Please upload onto Ocella the email below which is a further consultation response from the **Local Highway Authority** to discharge of condition application **A/157/20/DOC** relating to Land South of Water Lane, Angmering.

I'd confirm that the CMP dated 9<sup>th</sup> November 2020 (reference A290-R002/H) is now acceptable to satisfy the highway requirements of condition 21.

Appendix C – Routing Plan

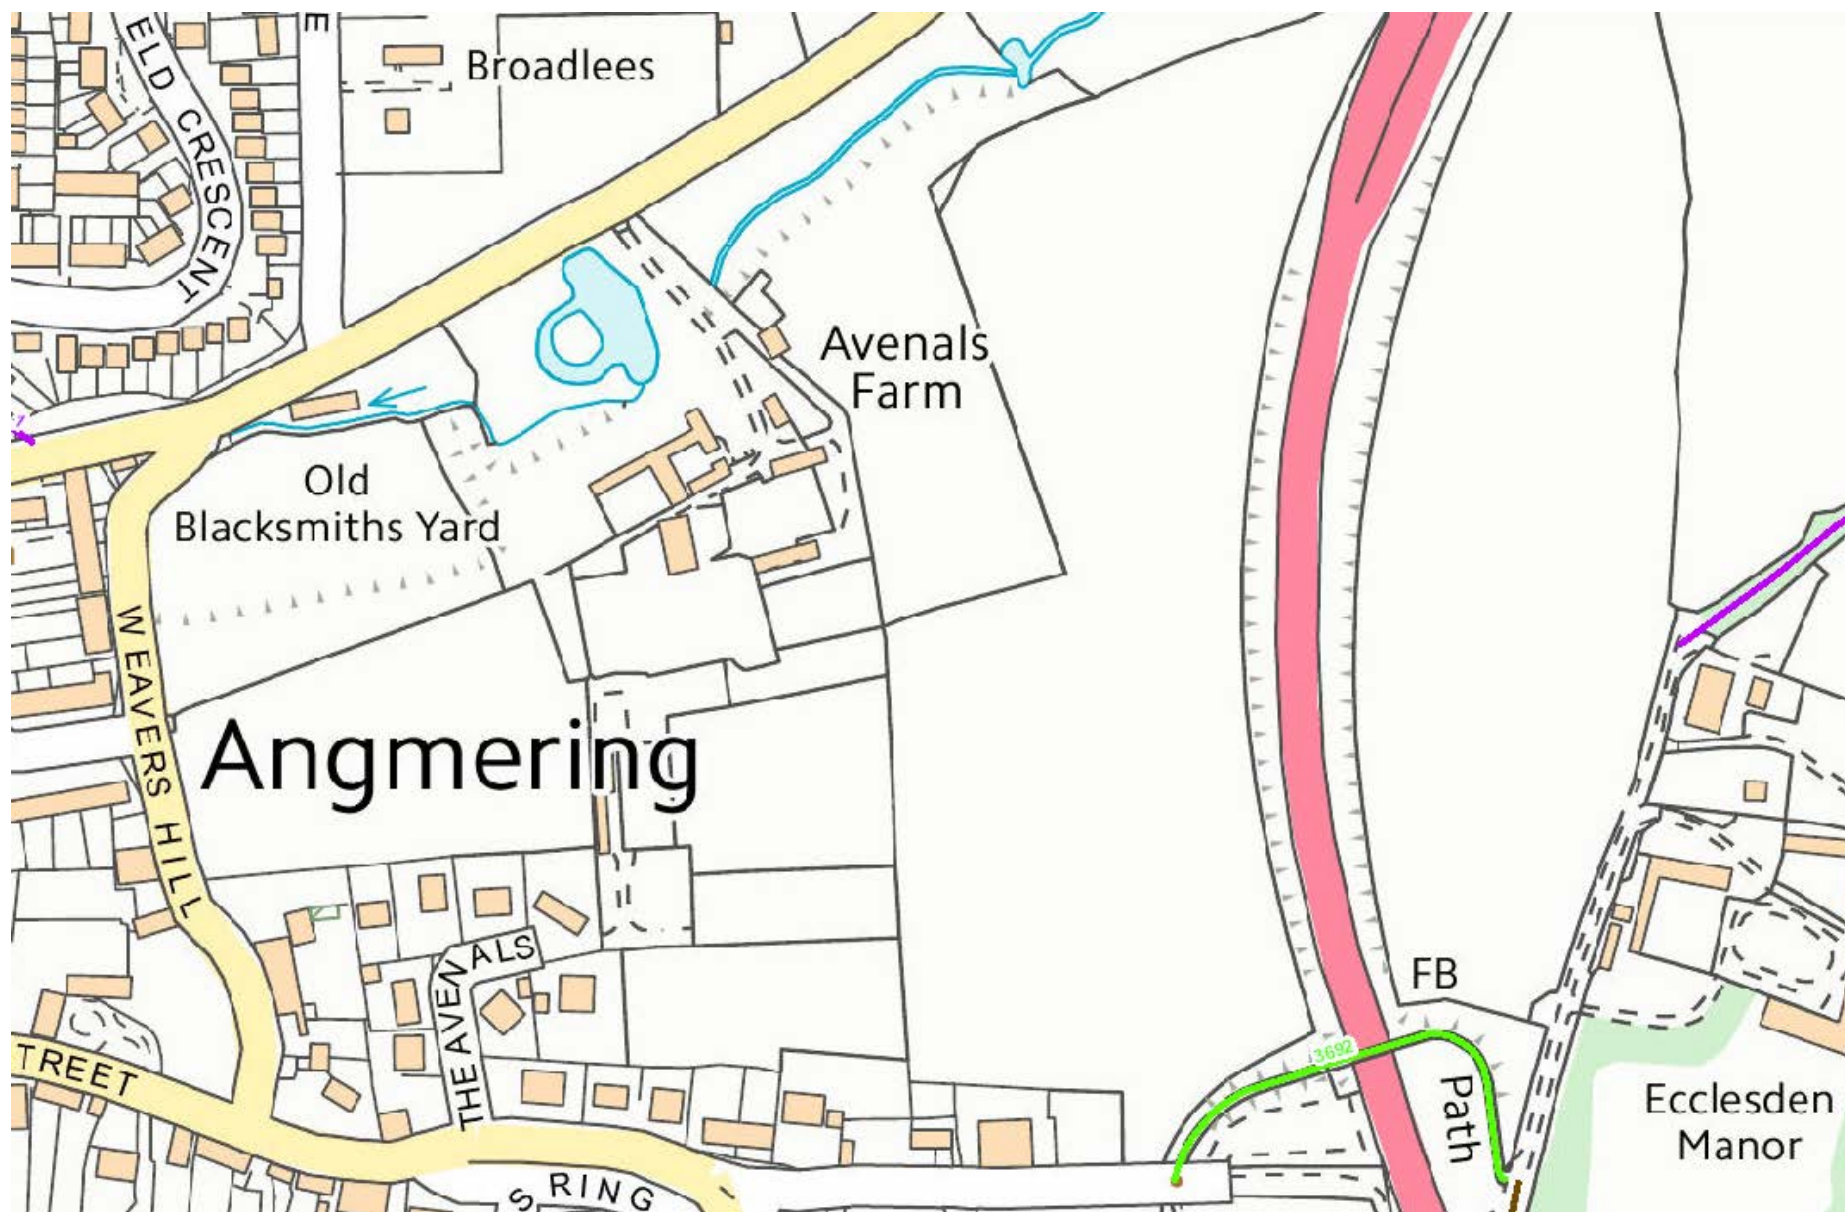
Vehicle routing has now been shown to completely avoid Angmering village throughout the period of construction.

To follow on, the edits are contained within Paras. 2.1 – 2.7, with an amendment to the routing plan (Appendix C)
